DELEGATED HOUSEHOLDER DECISION

Item No.	Report of the Interim Director of Planning, Regeneration & Public Realm		
Address:	77 YEADING LANE HAYES		
Development:	Erection of a two storey extension to the rear of the dwelling with new rear facing window at first floor level, amendments to fenestration and internal alterations.		
LBH Ref Nos:	59447/APP/2023/740		
Drawing Nos:	2023/77/YLH/303A Location Plan 2023/77/YLH/302 2023/77/YLH/301 2023/77/YLH/304		
Date Plans received:	Date(s) of Amendments(s):	12-03-23	
		12-03-23	
Date Application valid		05-05-23	
		12-03-23	
		12-03-23	
		12-03-23

PROPOSED GROUND FLOOR PLAN

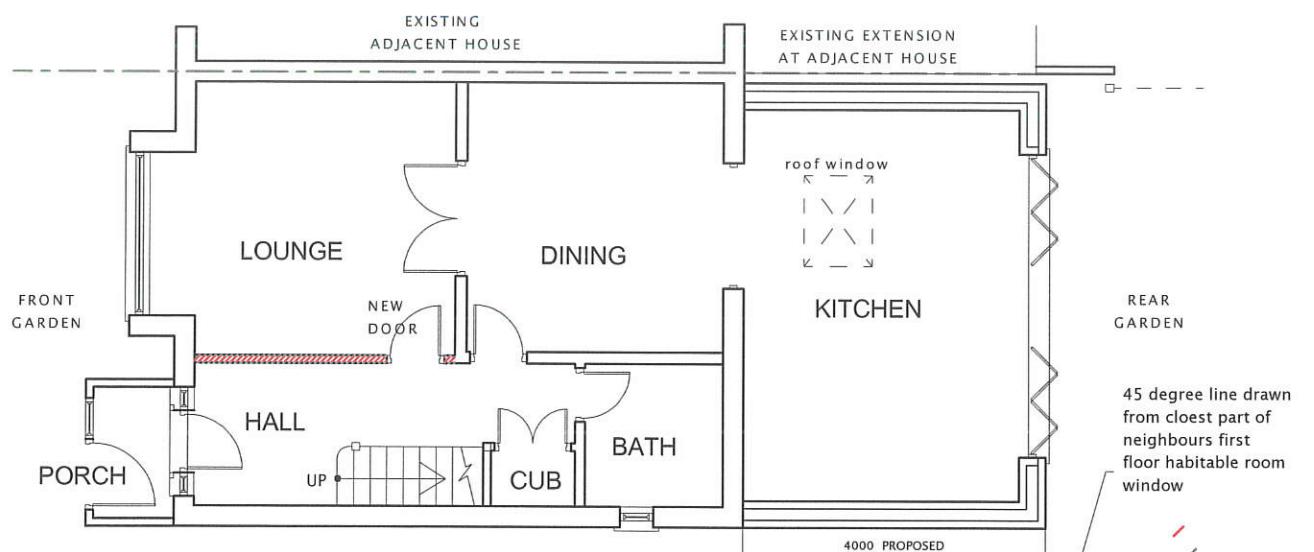
The proposal would see the erection of a single storey rear extension at ground floor, with the same measurements as the existing form. Whilst it would exceed the measurements set out in Policy DMHD1, the form currently exists and a larger ground floor extension has been recently approved under 59447/APP/2023/737.

The two properties on either side, 75 and 79 Yeading Lane both benefit from rear extensions, to which this proposal would not project further than 3.6m than the existing rear elevations of both neighbouring sites, which is outlined in Policy DMHD1 as an appropriate guideline when seeking to protect neighbouring amenity. Given the modest height of the proposals it is unlikely that there would be undue impact caused to the amenities of the occupiers at No 75 or 79 Yeading Lane through loss of light, outlook or sense of enclosure.

PROPOSED FIRST FLOOR PLAN

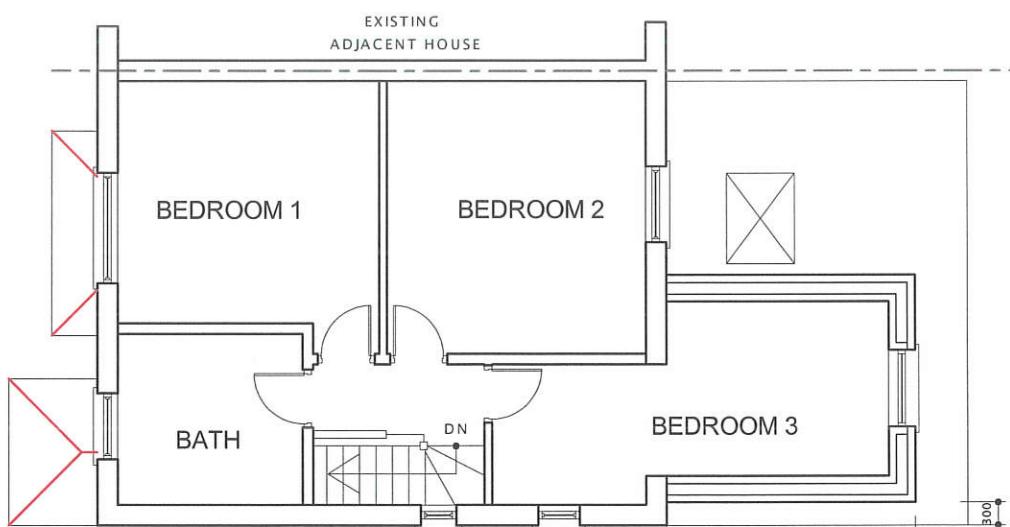
The first floor level complies with the requirements of Policy DMHD 1 as it has been set down from the main roof ridge substantially, is limited in terms of its width and it respects the 45 degree line of sight of both neighbouring properties.

The first floor element would be limited in depth and has been shown not to impede the 45 degree sight lines of both neighbours. The resultant form would not result in a level of loss of light, outlook or appear overdominant and overbearing that would be harmful to the neighbouring occupier amenities.

DRAWING TITLE:
PROPOSED ELEVATIONS

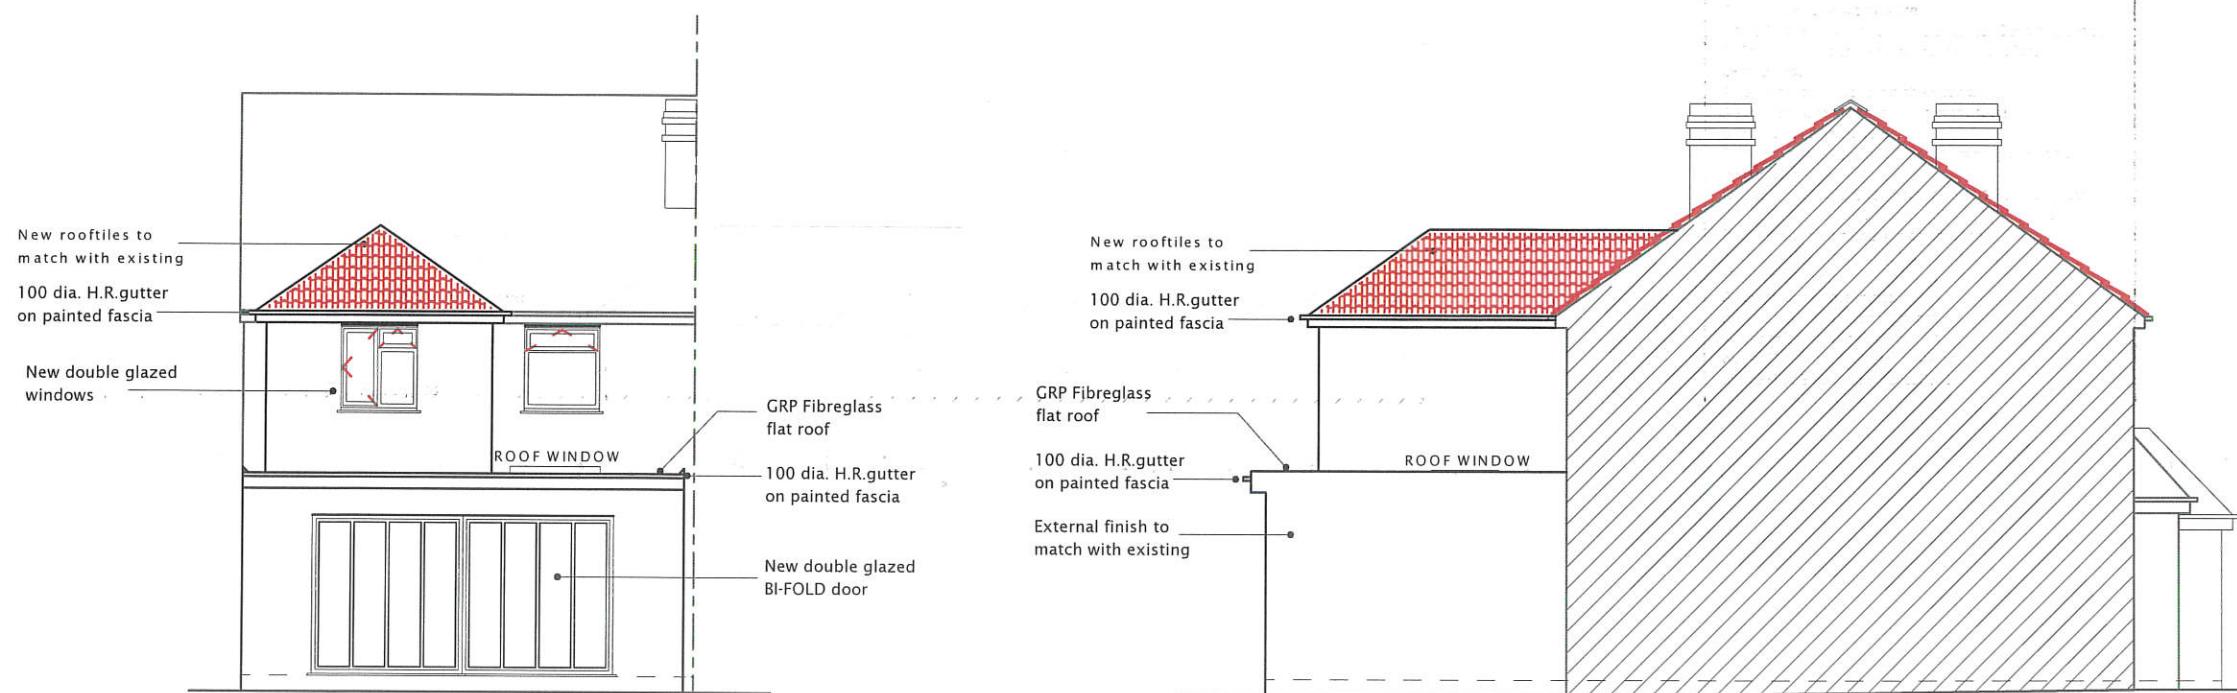
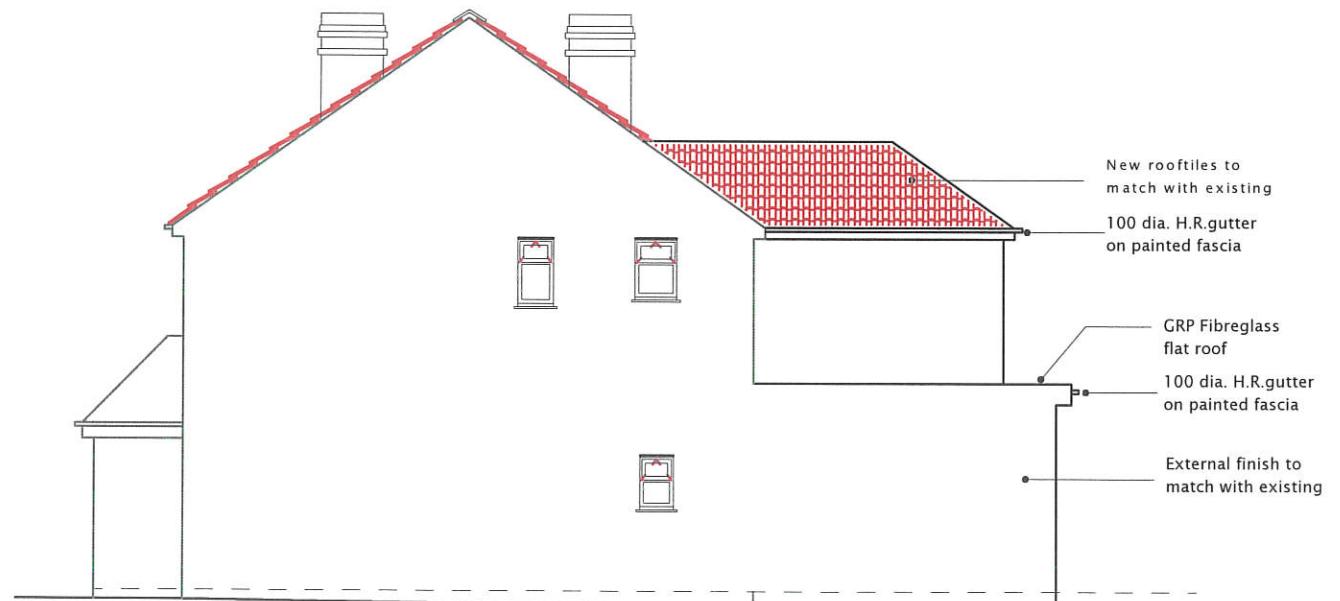
There would be no additional doors on the flank elevations of the proposal facing neighbouring spaces.

Notwithstanding the provisions of the Town and Country Planning (General Permitted Development) Order 2015 (as amended) (or any order revoking and re-enacting that Order with or without modification), no additional windows, doors or other openings shall be constructed in the walls or roof slopes of the development hereby approved facing 75 or 79 Yeading Lane.
